21/08/2019

Loreto Normanhurst School Redevelopment (Concept Proposal and Stage 1) (SSD-8996)
Request for response to the Department's key issues

ATTACHMENT 1: Key Issues

Drawing Title
SITE ELEVATIONS

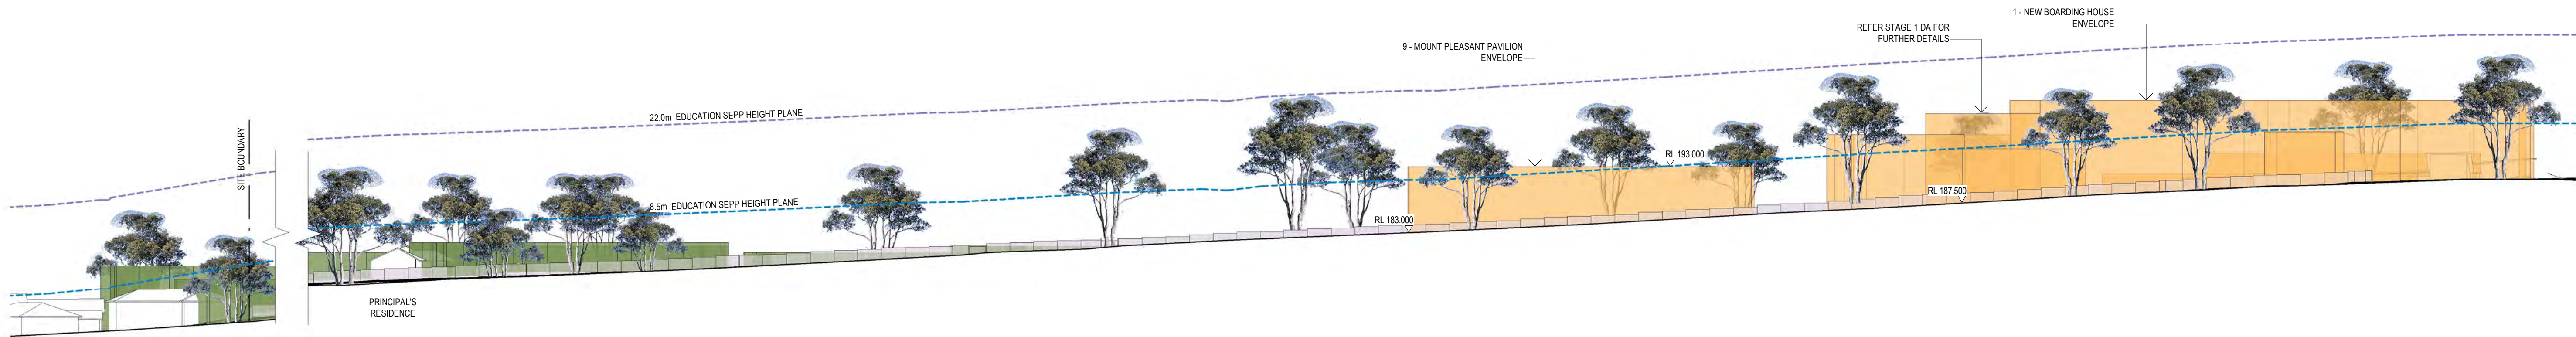
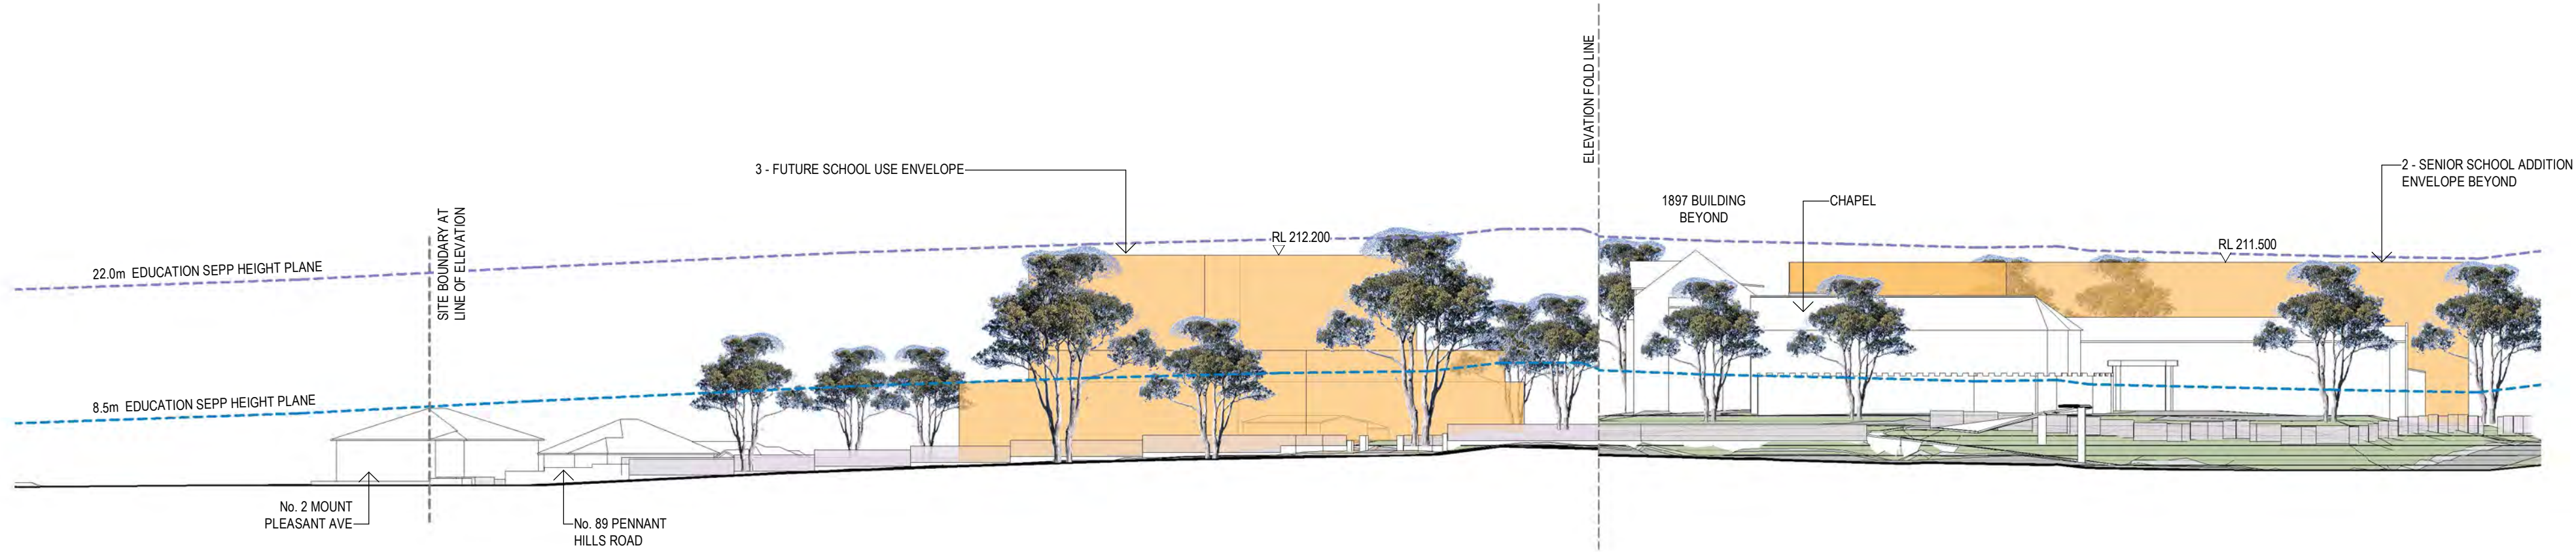
- Building envelope 3 would have an unreasonable visual impact on the adjoining residences fronting Mount Pleasant Avenue, due to its bulk and height. Further details of this building envelope are required to assess its impacts on the site and the surroundings and demonstrate that this location is suitable for the development.

- The submitted architectural plans do not include details of the setbacks to Mount Pleasant Avenue or dimensions of the rooms / building heights. Notwithstanding, the Department considers that the boarding house has a significant and elongated

footprint without breaks, monotonous materials and finishes, and insufficient setback (minimum 6m) to Mount Pleasant Avenue.

Drawing Title
SITE ELEVATIONS

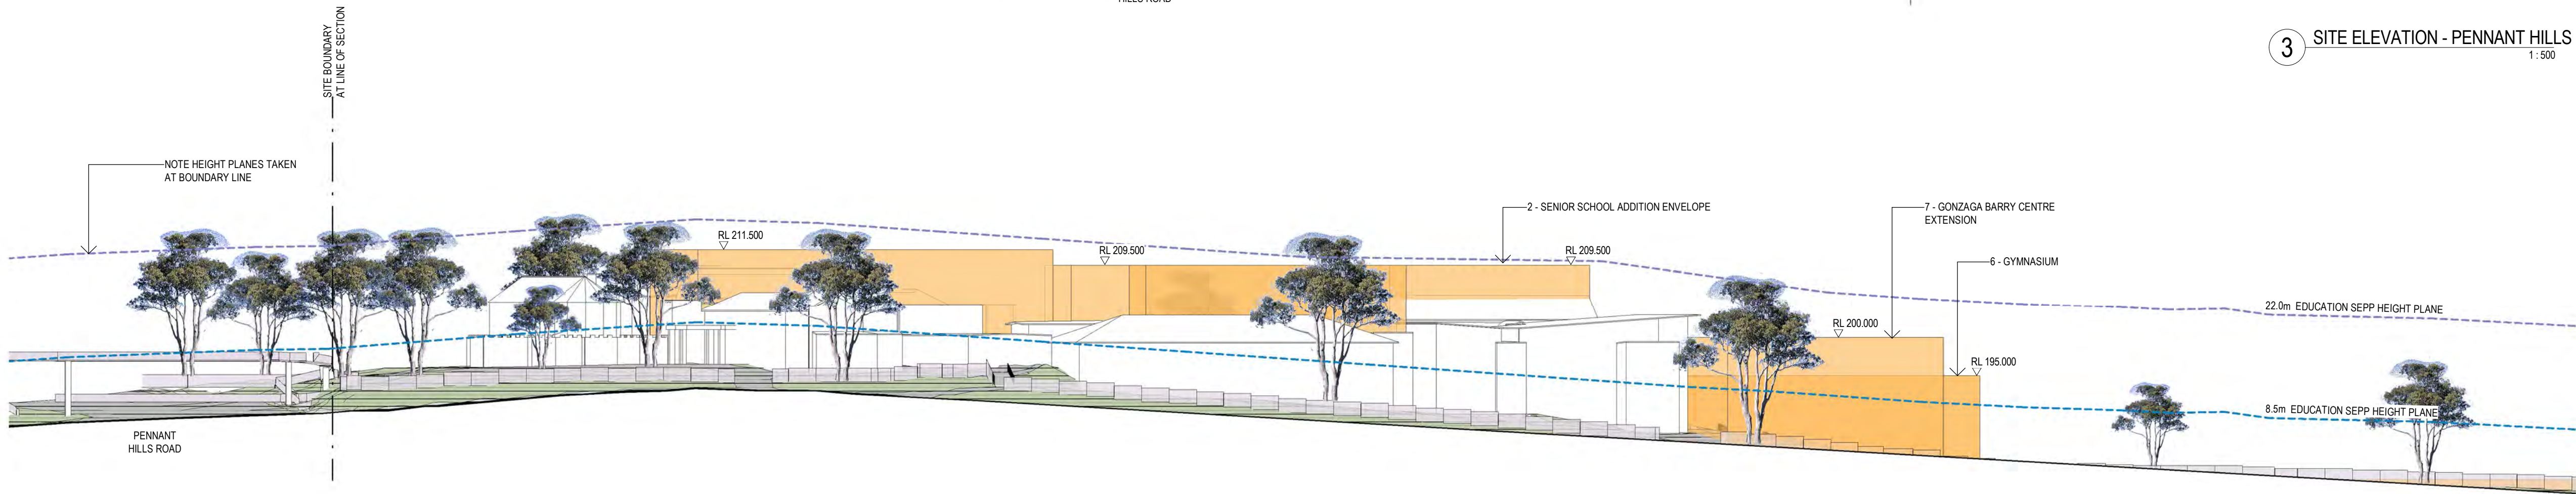
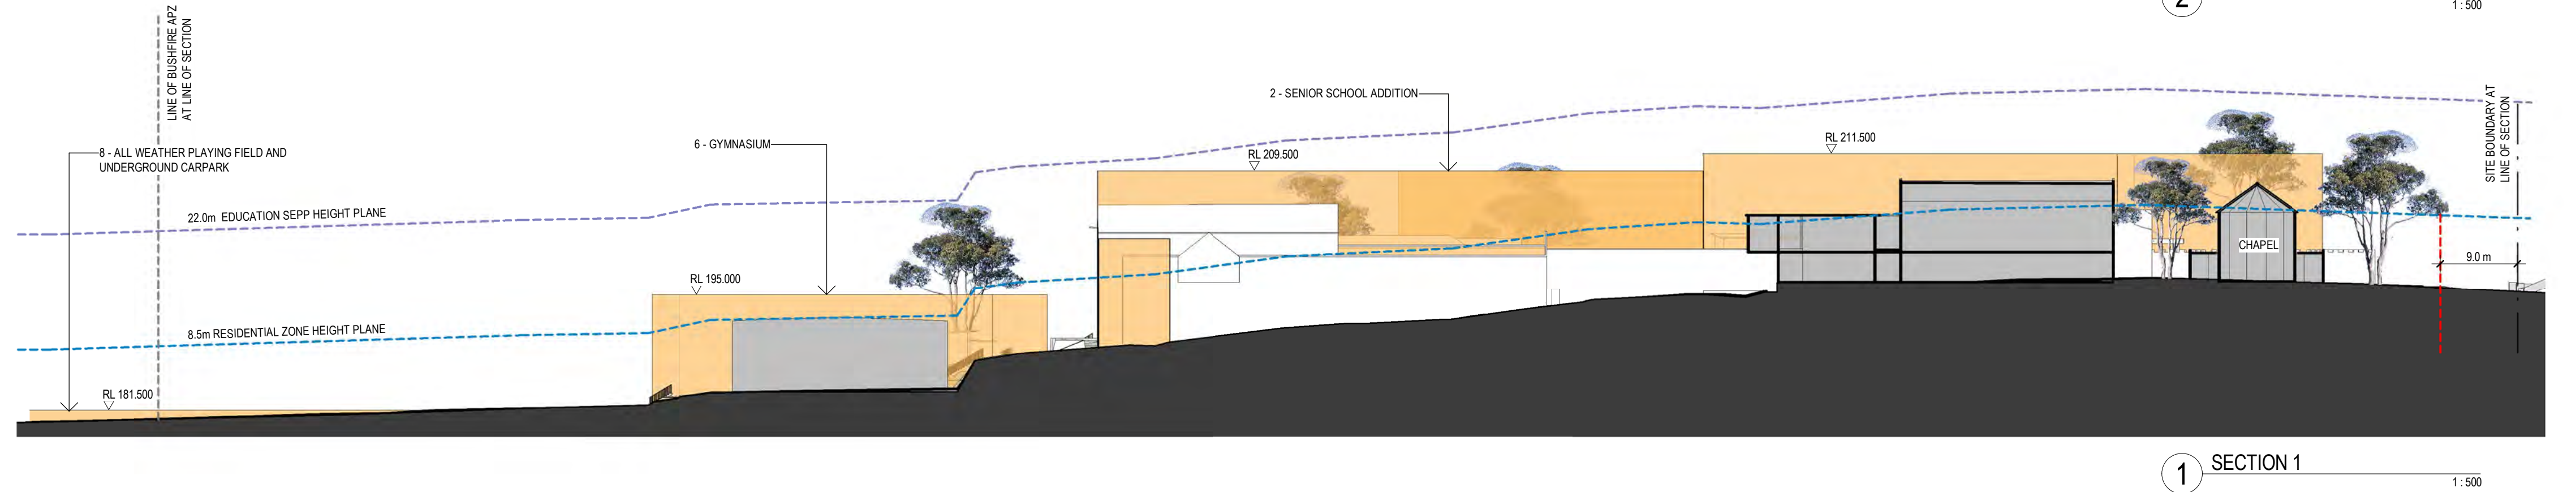
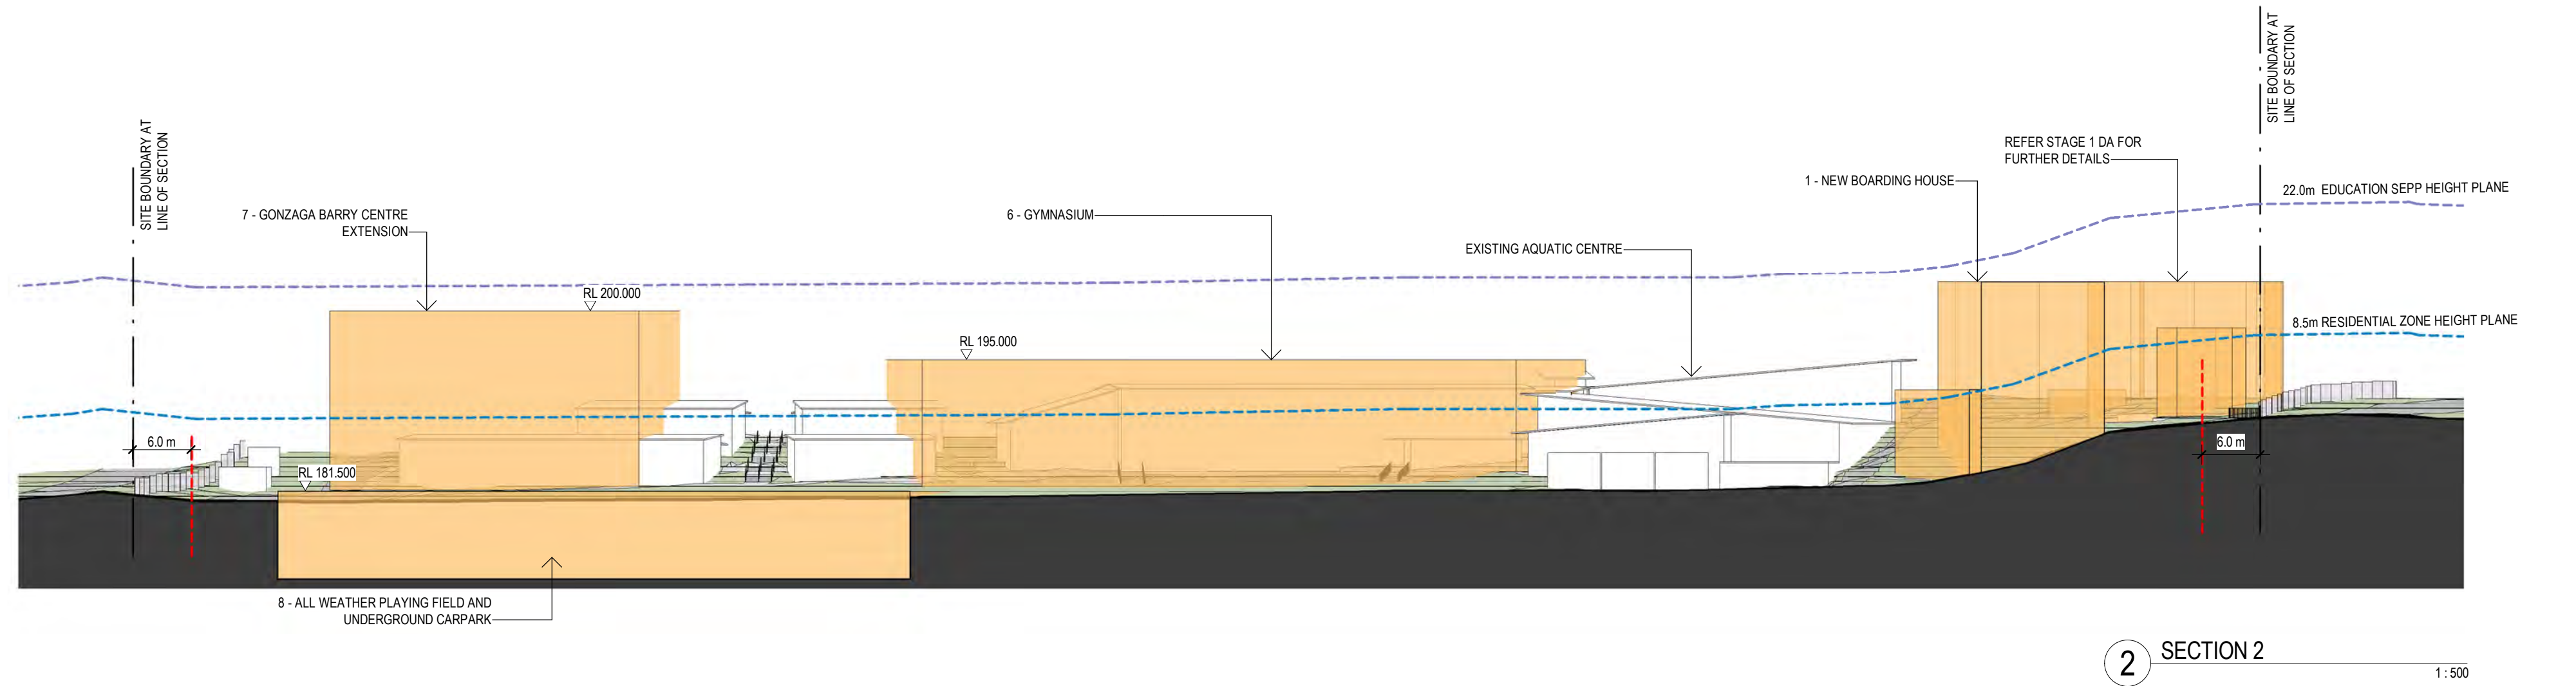
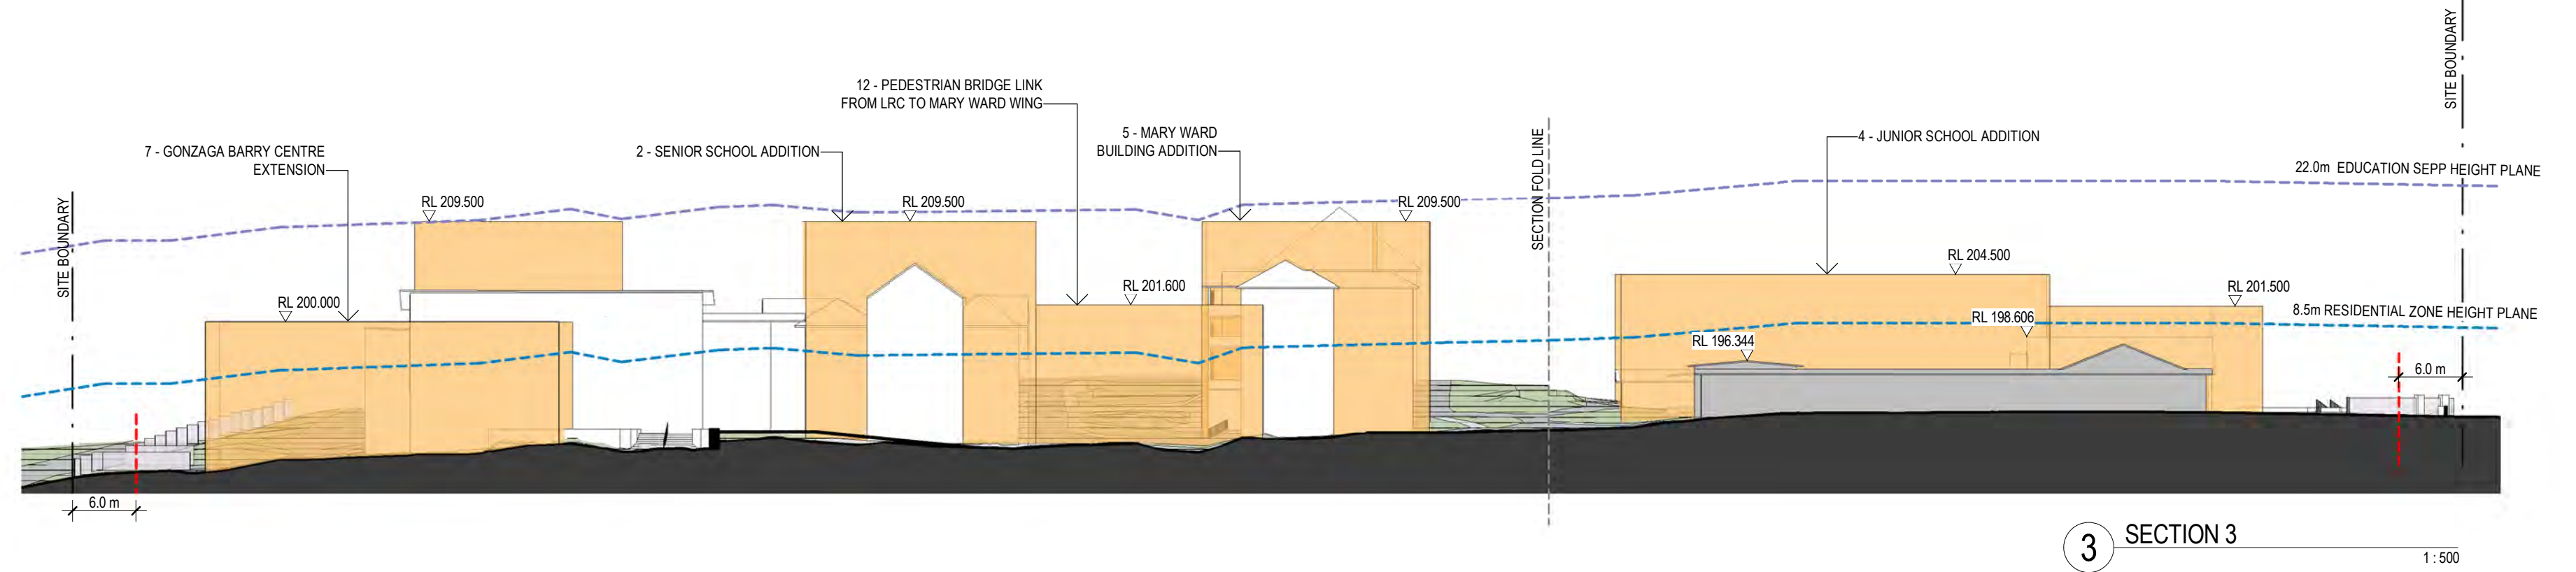
- The setback of building envelope 2 from Osborne Road, in addition to the proposed maximum height, would have a detrimental impact on the low-density residences on this road, as well as the buildings within the site.

- No noise logger has been placed at Osborn Road for noise measurement. Therefore, the application has not established the Noise Management Levels (NMLs) for sensitive receivers at this location. However, the Noise report concludes that Building N (located along the Osborne Road frontage and likely accommodating the auditorium in the future) can comply with the NMLs. This conclusion cannot be supported without additional noise measurements and these must be provided with the application.
